Harbour Energy Proposed Protective Provisions

Shown as mark-up to the Harbour Energy Without Prejudice Protective Provisions as Submitted by the Applicant at DL5

Doc No	FLO-MOR-GIS-MAP012-Protective Provisions-Rev001	Rev	02
Alt Doc No	n/a		
Document Status	Approved for Use	Doc Date	11 March 2025
PINS Doc Ref	3.5	APFP Ref	n/a

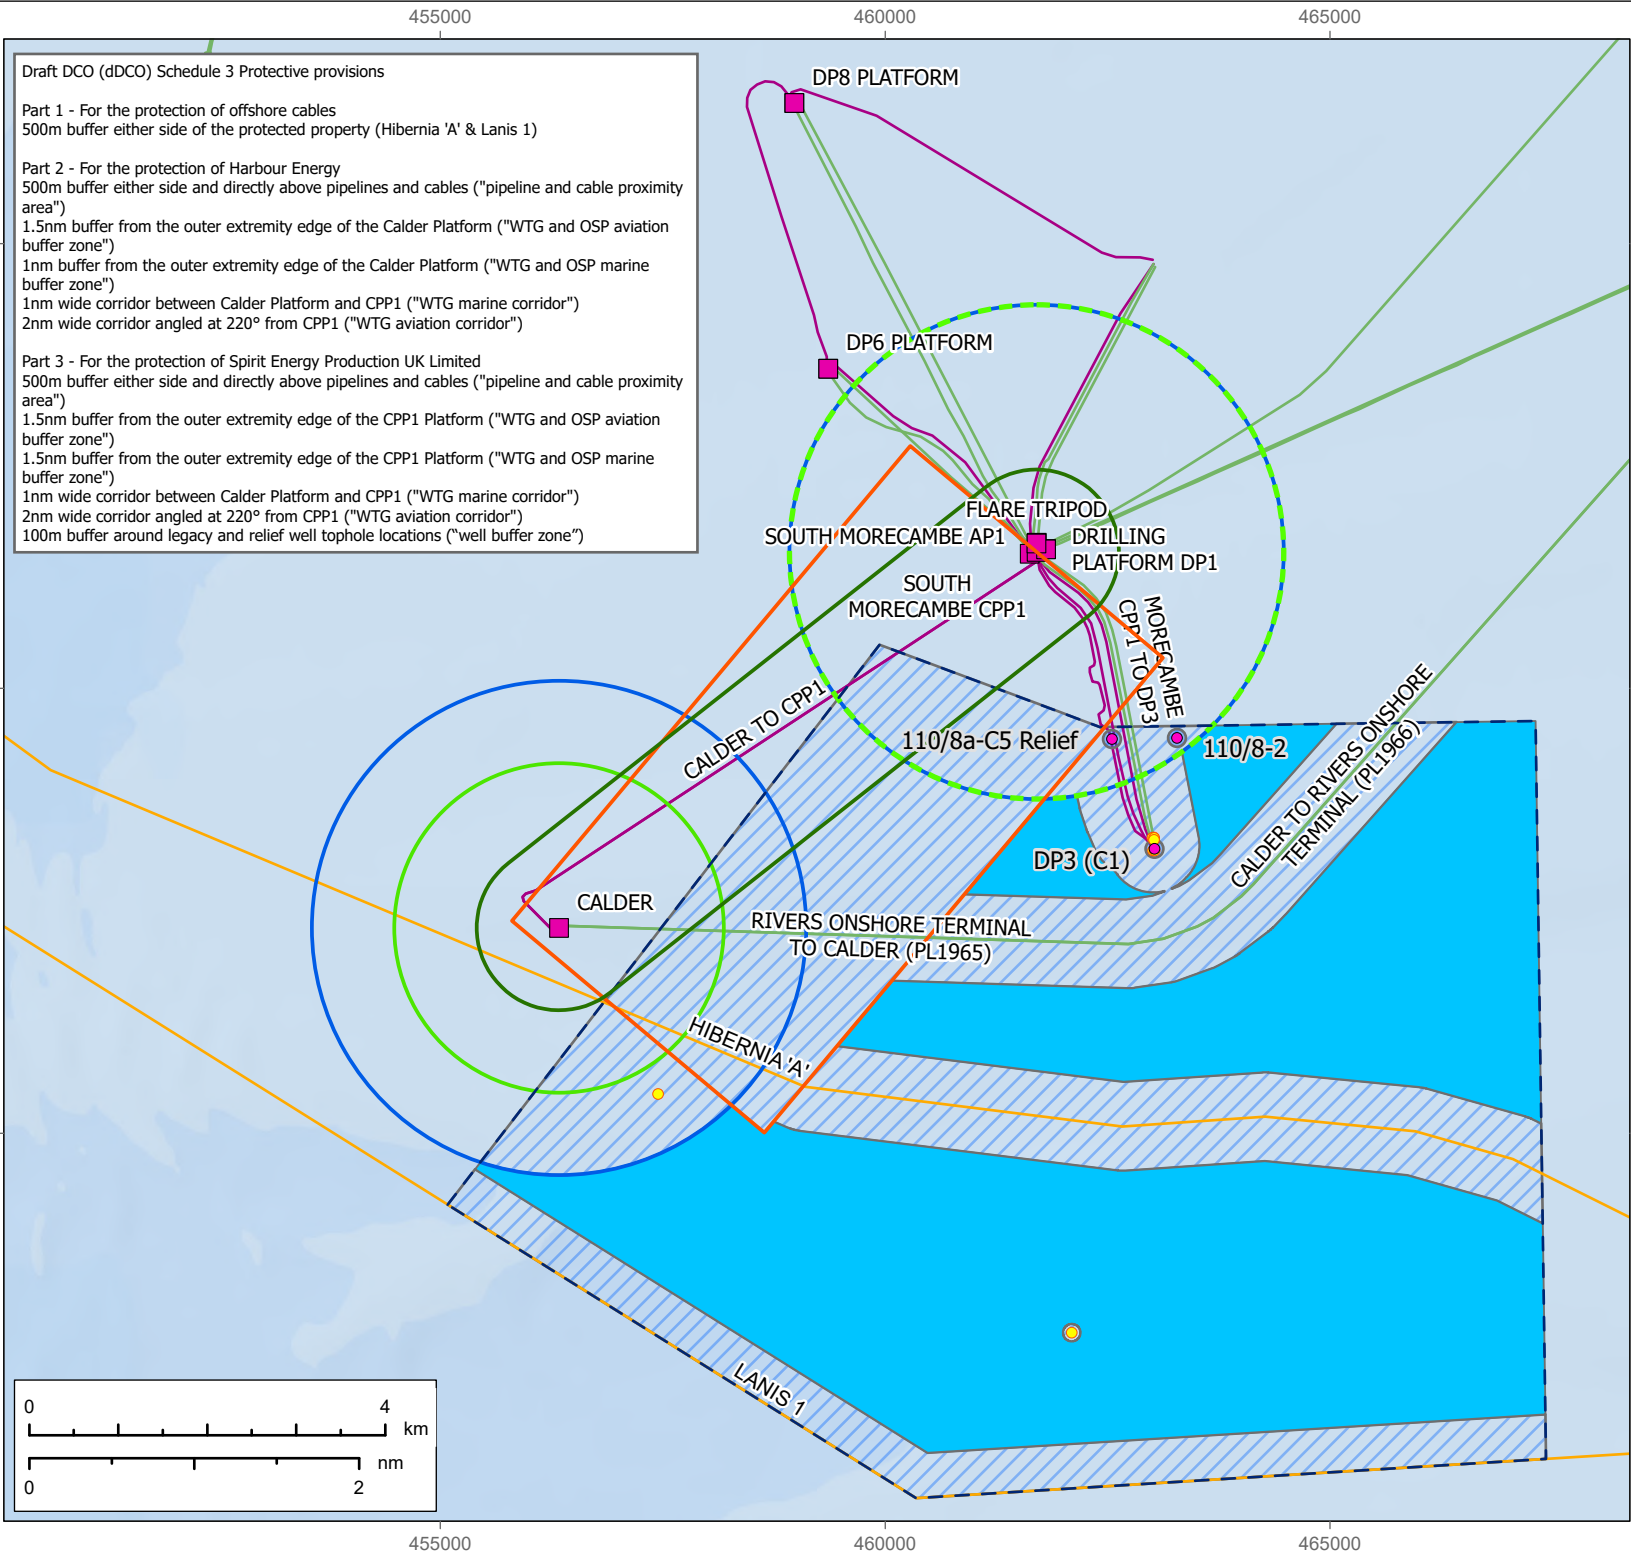
Commented [HBR3]: The requirement in square brackets at (v) is subject to paragraph 4.1 and the definition of “**WTG and OSP aviation buffer zone**” being included as drafted in this version of the PPs. i.e. the **WTG and OSP aviation buffer zone** being set at 3.76nm.

“**WTG and OSP aviation post-COP buffer zone**” means a circular area of **one point nine nautical miles (1.9 nm)** of clear airspace measured from the nearest outer extremity edge of the Calder Platform to any tip from any wind turbine generator located within the **order limits** and extending vertically from mean sea level, shown edged blue and annotated and shown as the WTG and OSP aviation post-COP buffer zone on the Spirit and Harbour Protective Provisions Plan;

Commented [HE7]: In the interests of co-existence, and as a development from earlier submissions, Harbour Energy is willing to accept that, with suitable compensation provisions, post-COP decommissioning work could be undertaken with rotor tips no nearer than 1.9nm. As clearly set out in Harbour Energy’s Written Representation (REP1-102), the AW169 aircraft used in the East Irish Sea require an obstacle-free distance of 1.9nm upwind of a helideck in order to execute a take-off or a missed approach should one engine become inoperable. The Applicant has challenged this distance but Harbour Energy re-iterates that this distance has been confirmed by our aviation specialists by reference to the performance graphs in the aircraft operating manual and also by the helicopter operator operating these aircraft on behalf of Spirit Energy, including those to the Calder Platform. In support of this change from Harbour Energy’s DL5 submission (in which 3.76nm was required for both pre-COP and post-COP operations), the drafting of these protecti... [1]
